LHAP MAIN WORKS (SSD 10389) - Addendum Letter

Liverpool Hospital
Elizabeth Street, Liverpool
NSW 2170
200903 SSDA MAIN WORKS Addendum (02)

Fitzpatrick+Partners are the architect for the above-mentioned project. The following responses to SSD 10389 have been received. Our response to these items is included below.

CAMPUS VISITOR BICYCLE PARKING LOCATIONS

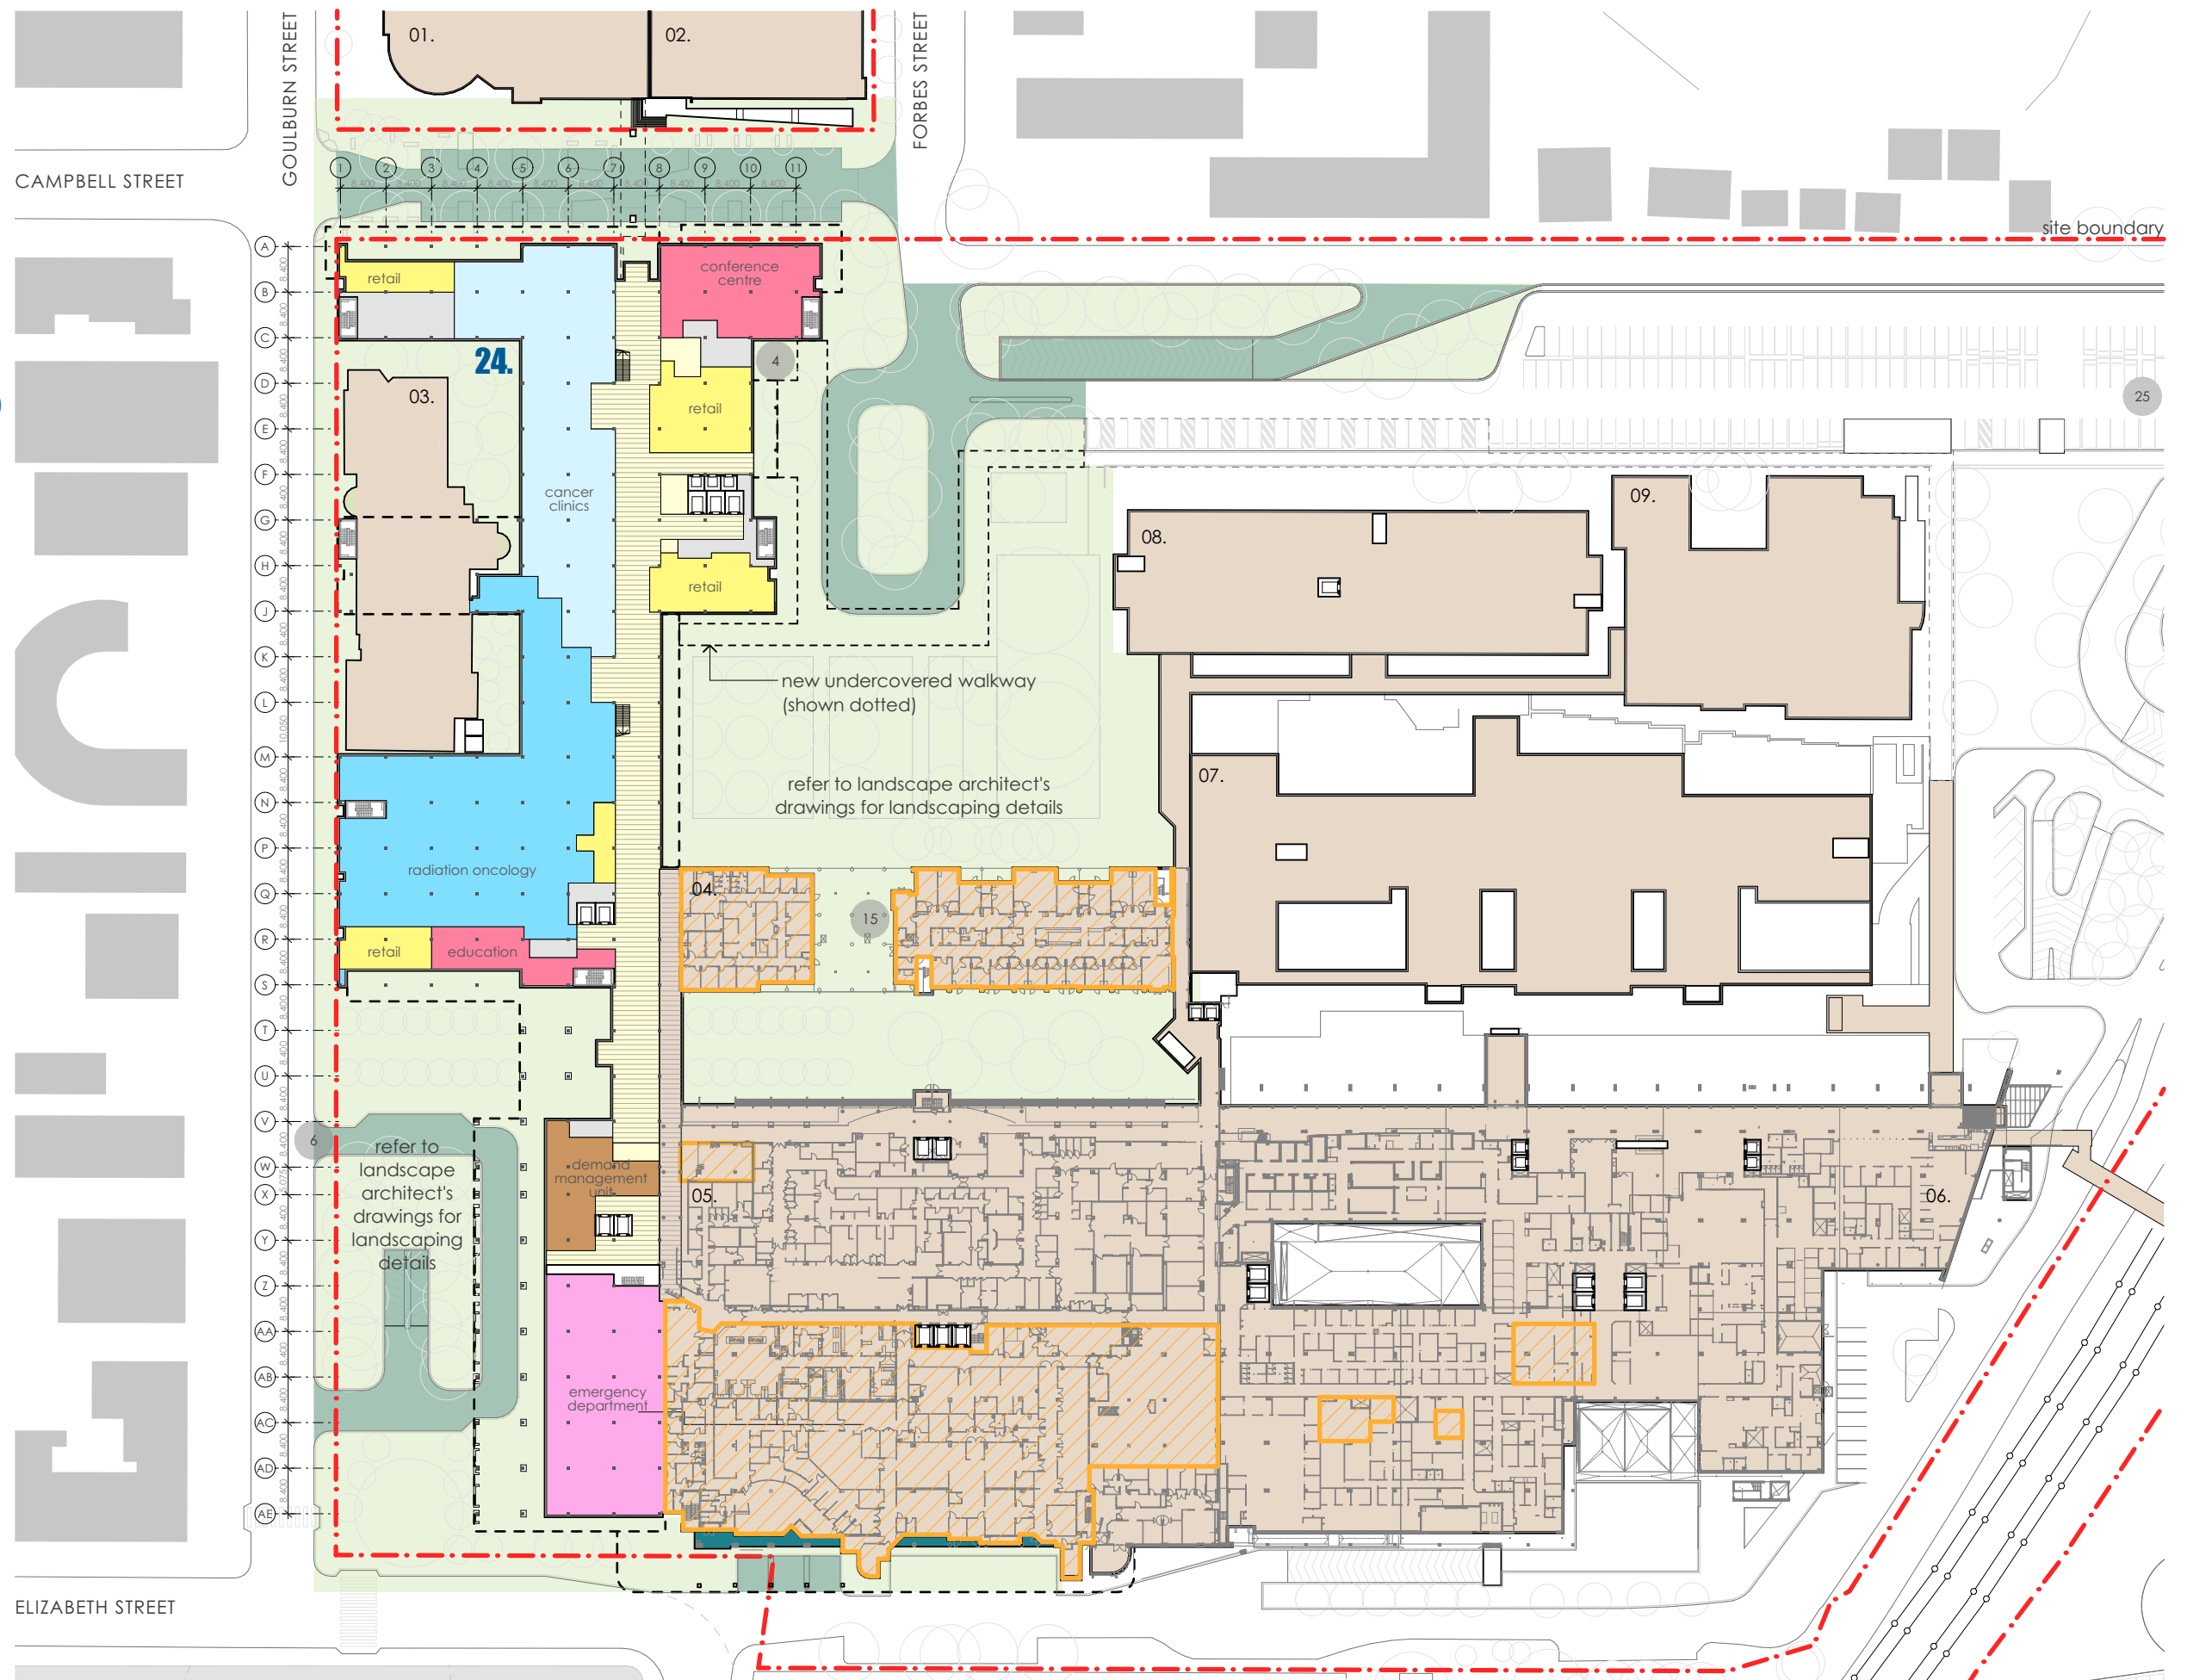
Promote more pedestrian circulation within the building elements and improve accessibility and connectivity to the surrounding street network.

A-SSDA-MW-08 GROUND PLAN (amended drawing)

- Visitor bicycle parking locations shown throughout the campus (50 in total)

continue to A-SSDA-MW-28

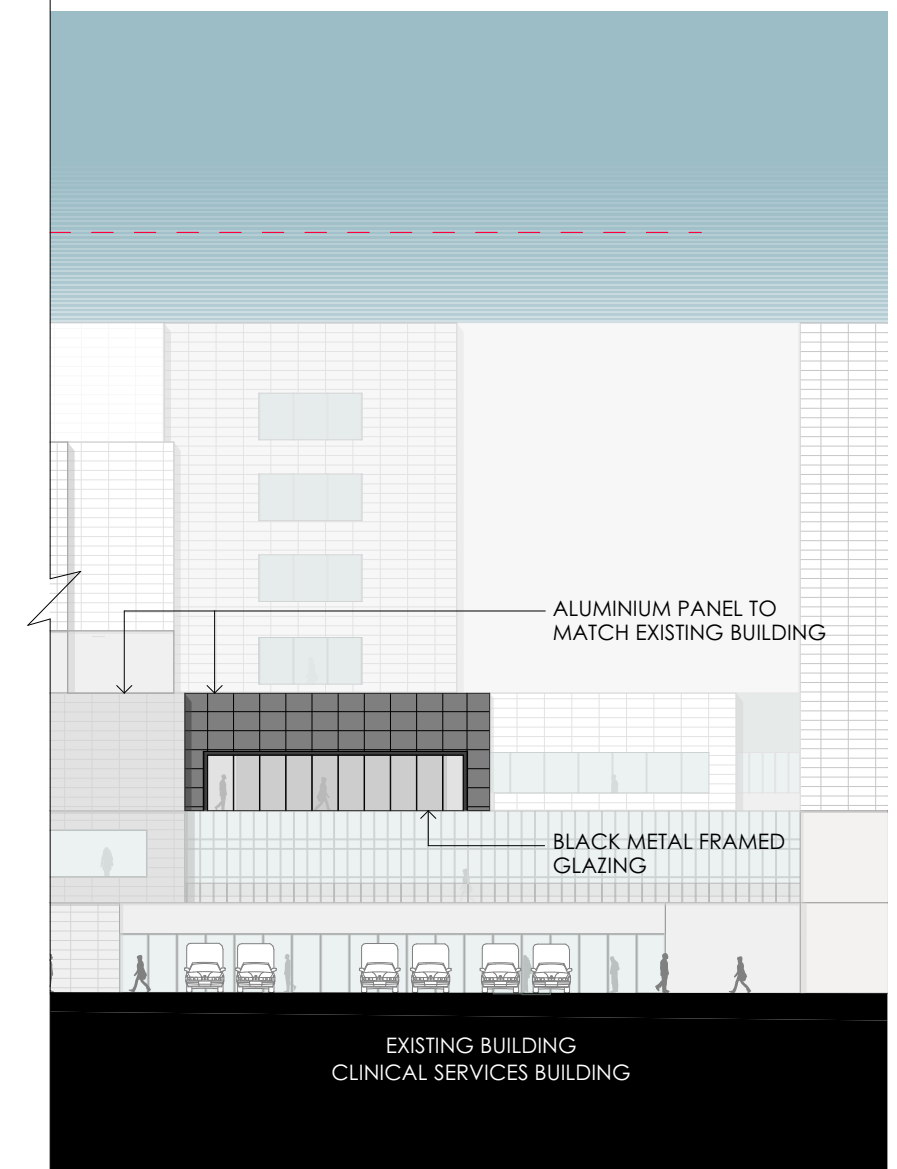
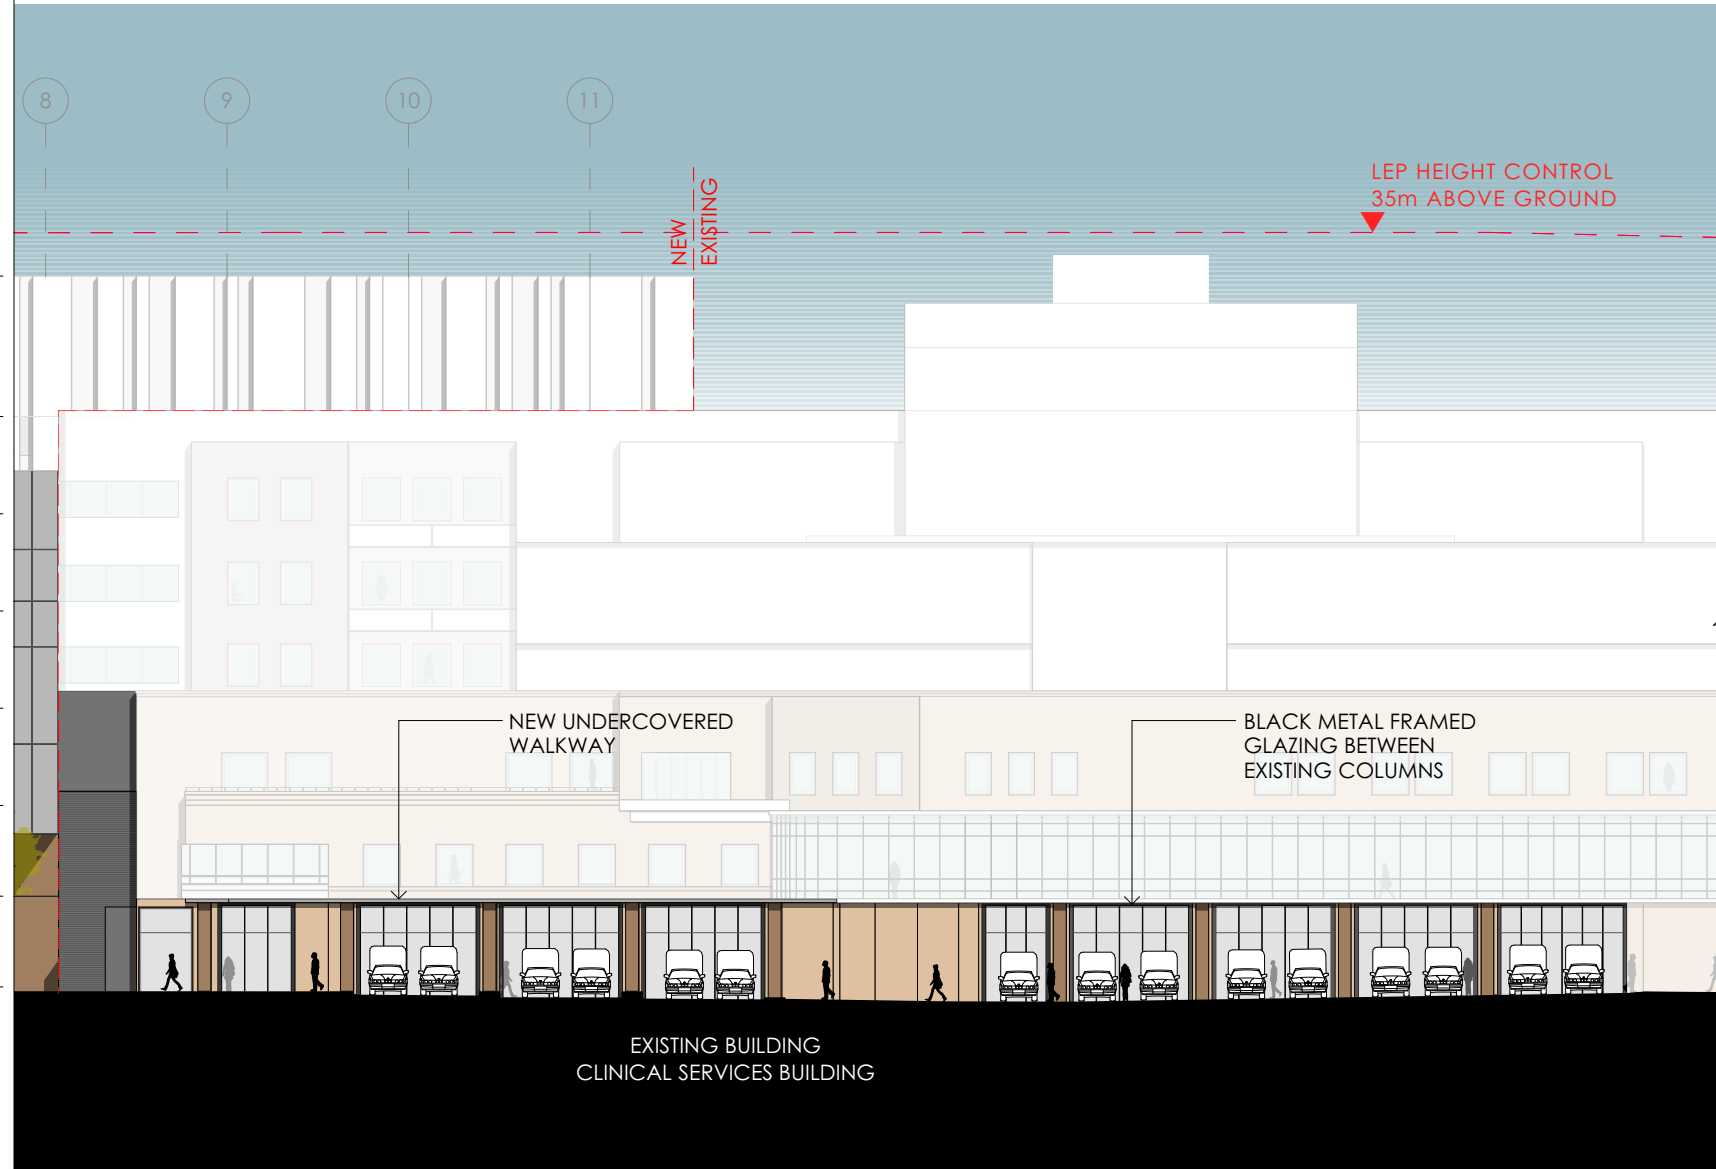
The architectural style and building façade details proposed for the western façade of the emergency department building needs to be replicated on the southern façade, to ensure consistency and legibility in the built form.

Innovative ways to blend the existing and proposed building facades along the southern side of the hospital building (i.e. facing Bigge Park) should be considered, to minimise the stark contrast and difference in quality between the existing and the proposed sections of the building.

The South Podium building is composed of an interplay between two main elements; an elevated and glazed two storey box which is then 'wrapped' with a vertically expressed brick facade. The glazed box extends beyond the brick portion on the southern end to clearly articulate these two elements and 'celebrate' the end of the building. It also allows for glazing to the upper levels, maximising south-facing views to Bigge Park.

Minor amendments are proposed in line with Council's response (second item) to incorporate additional brick elements on the lower levels to provide a more sensitive response to the adjacent Clinical Services Building. Further detail of this area, including the proposed amendments are included in Appendix A of this letter.

A-SSDA-MW-28 SOUTH ELEVATION (amended drawing)

- Revised South Elevation
